Your ref: SSD-80432461
Our ref: DOC25/1083704

Subject: Response to Submissions - Mixed-use development with in-fill affordable housing located at 2-6 Pilgrim Avenue and 11-13 Albert Road, Strathfield (SSD-80432461)

CPHR advice on EIS - Mixed-use development with in-fill affordable housing located at 2-6 Pilgrim Avenue and 11-13 Albert Road, Strathfield

Figure 16 Basement Section Plan (North-South)

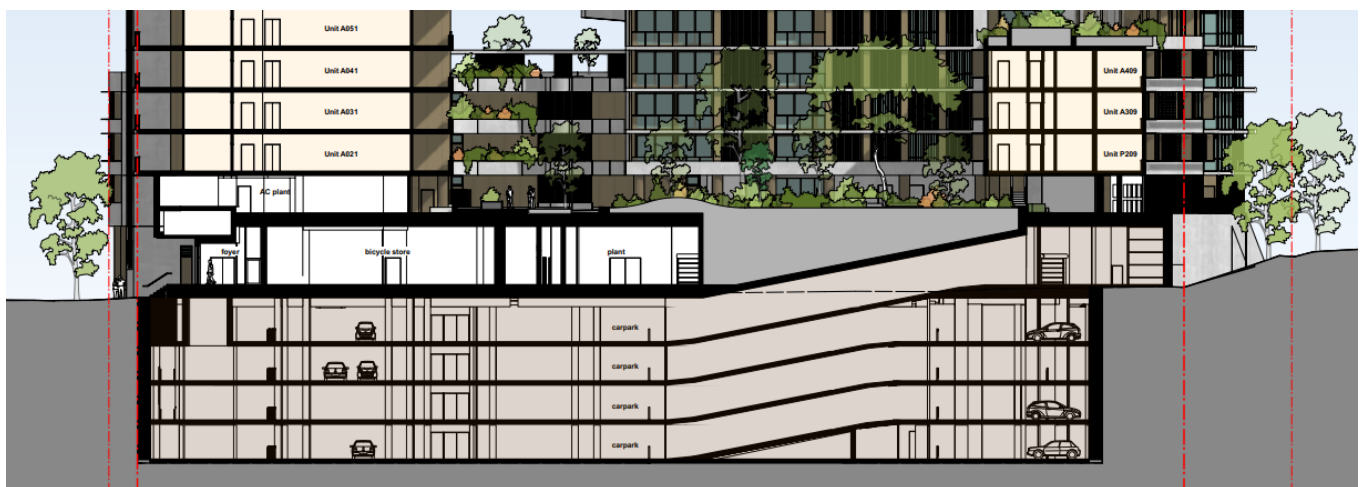
2	<i>Basement carparks</i>	The FIRA has not adequately assessed the risks to people associated with inundation with the multi-level basement carpark becoming inundated. The development includes 4-5 levels of basement carparking, with the driveway crest raised approximately 460mm above the 1% annual exceedance probability (AEP) flood level plus freeboard. In rarer events, the basement carpark will be inundated, with the probable maximum flood (PMF) level approximately 1.6m above the driveway crest level. Additionally, as the ground-floor level is below the PMF level, floodwater could also enter the basement through lifts, stairwells, and other service penetrations, further increasing the speed and depth of inundation. Under these conditions, the basement carpark could fill rapidly, potentially trapping occupants. Observed behaviour shows that some people will attempt to retrieve their vehicles when underground carparks flood. The FIRA asserts that the risk is acceptable as the driveway crest complies with the <i>Strathfield Development Control Plan 2005</i> (DCP) requirements. However, meeting prescriptive DCP controls does not ensure that all life-safety risks are mitigated. Strathfield does not have an adopted Flood Risk Management Study and Plan that has tested the adequacy and effectiveness of the relevant DCP flood-related controls. Recommended action: Nominate appropriate driveway crest levels and demonstrate that the flood hazard in the basement carpark during major flooding events are tolerable and that people can safely evacuate.

Figure 52 1% AEP Peak Flood Depth & Elevation – Post-Development Scenario

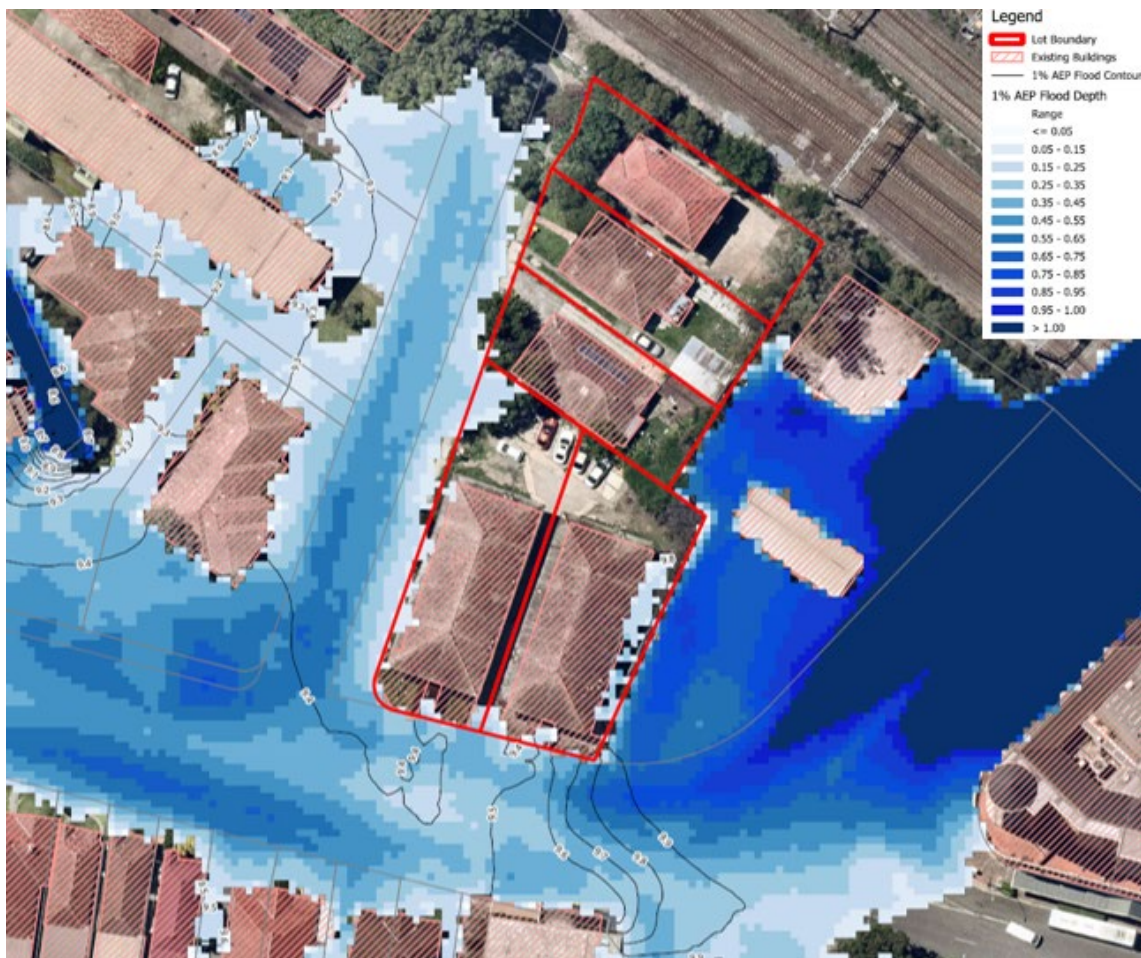
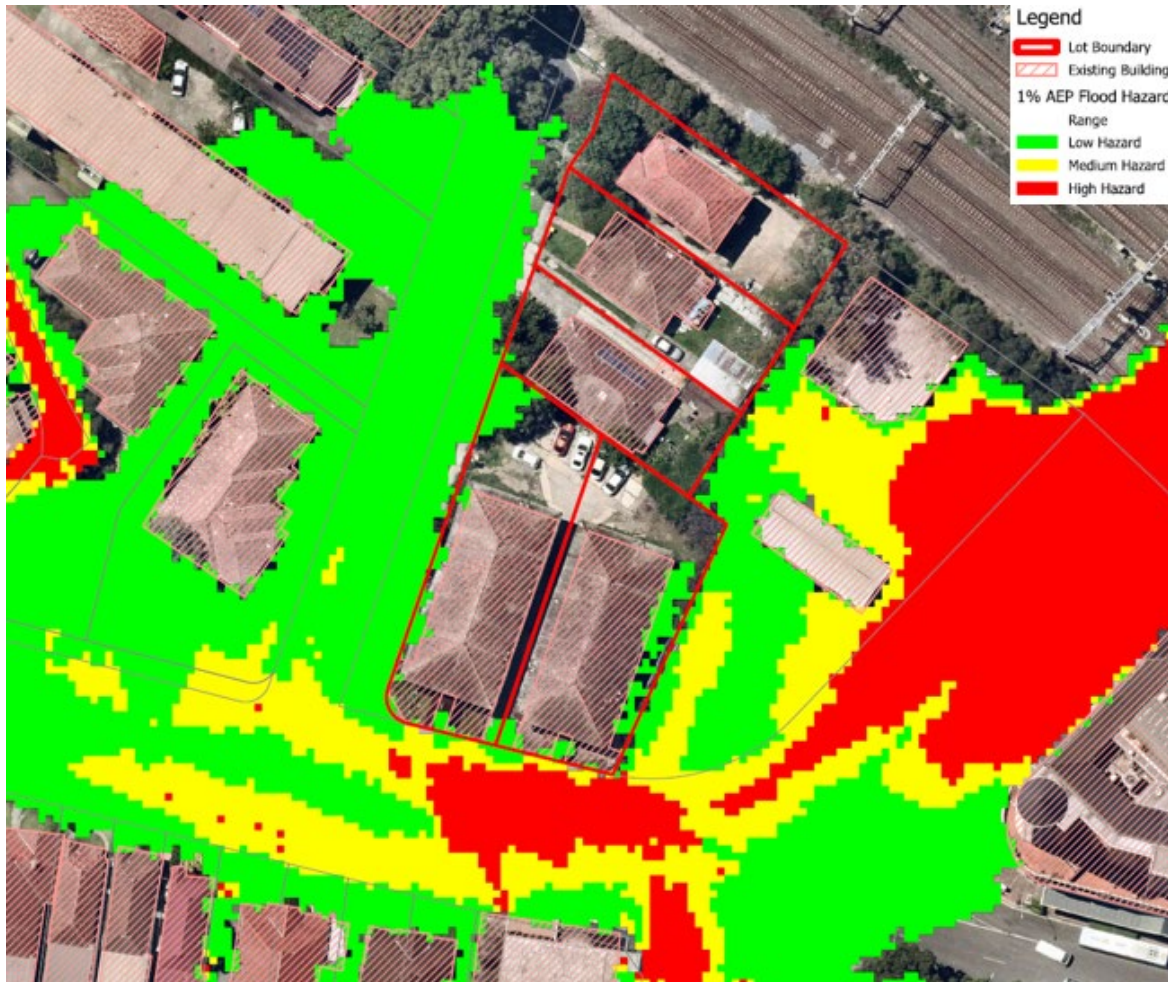
1	<i>Consideration of climate change</i>	The <i>Flooding Response Letter</i> has not adequately address CPHR's previous advice that the FIRA must consider climate change impacts. No modelling, calculations, or references are provided to justify the assertion that climate-change impacts are "minimal" and amount to only a few millimetres. Recommended action: Update the FIRA to assess climate-change impacts in accordance with the Flood Impact and Risk Assessment – Flood Risk Management Guideline LU01 (NSW DPE, 30 June 2023) and the Australian Rainfall and Runoff – A Guide to Flood Estimation Version 4.2 (Commonwealth of Australia, 2019).
	<i>Extent and Timing</i>	Pre-determination

Extent and Timing	Pre-determination
3	Consideration of Powells Creek catchment's flood risk	The RTS has not adequately addressed CPHR's previous advice that the FIRA should be updated using the Powells and Saleyards Creek Flood Study (Strathfield Municipal Council, November 2019) and assess the full range of relevant flood events. The provided FIRA remains unsuitable for assessing flood behaviour at the site and does not satisfy the requirements of <i>Flood Impact and Risk Assessment – Flood Risk Management Guideline LU01</i>. Key deficiencies include: • Use of a non-validated local model: The <i>Flooding Response Letter</i> relies on a hydraulic model originally prepared for DA2020/256 and asserts it was "approved" by Strathfield Municipal Council (Council). A model reviewed by Council for the purpose of a development application is not an adopted or approved model. Furthermore, it does not have the weight of a Council-led and endorsed study that has been put on public exhibition and it may also be unsuitable for future applications. The <i>Flood Impact and Risk Assessment – Flood Risk Management Guideline LU01</i> requires that any non-adopted model be validated against known flood events or the adopted Council model. • Misrepresentation of floor-level protection: The <i>Flooding Response Letter</i> states that floor levels are set 500mm above the 1% AEP flood level, implying a level of protection exceeding the 1% AEP flood. However, freeboard is a safety margin to account for uncertainties in modelling and real-world behaviour and cannot be used to increase the depth above the Defined Flood Event at which a property will flood. • Failure to assess the full range of flood risk: The FIRA has only modelled the current-day 1% AEP event and states that a PMF assessment is unnecessary because, "the first floor is anticipated to be above PMF." This does not satisfy the requirements of the Secretary's environmental assessment requirements (SEARs) or the advice contained in the <i>Flood Impact and Risk Assessment – Flood Risk Management Guideline LU01</i>. The <i>Flood Impact and Risk Assessment – Flood Risk Management Guideline LU01</i> advises that multiple design events are assessed, including the 10%, 5%, 1%, 0.5%, 0.2% AEP and PMF, to properly assess hazard, flood behaviour, emergency management feasibility, and compatibility with the site's risk profile. Without PMF modelling, the FIRA cannot determine whether the development is compatible with the site's flood risk. • Identification of key hydraulic features: The FIRA does not identify or discuss the key hydraulic controls or interactions that influence local flood behaviour. • Australia Rainfall and Runoff (ARR) version used: The FIRA should specify which version of ARR was used in the assessment as different editions contain substantially different guidance on how to consider climate change.

Recommended action: Revise the FIRA to satisfy the requirements of the <i>Flood Impact and Risk Assessment – Flood Risk Management Guideline LU01</i> and the SEARs.
	<i>Extent and Timing</i>	Pre-determination
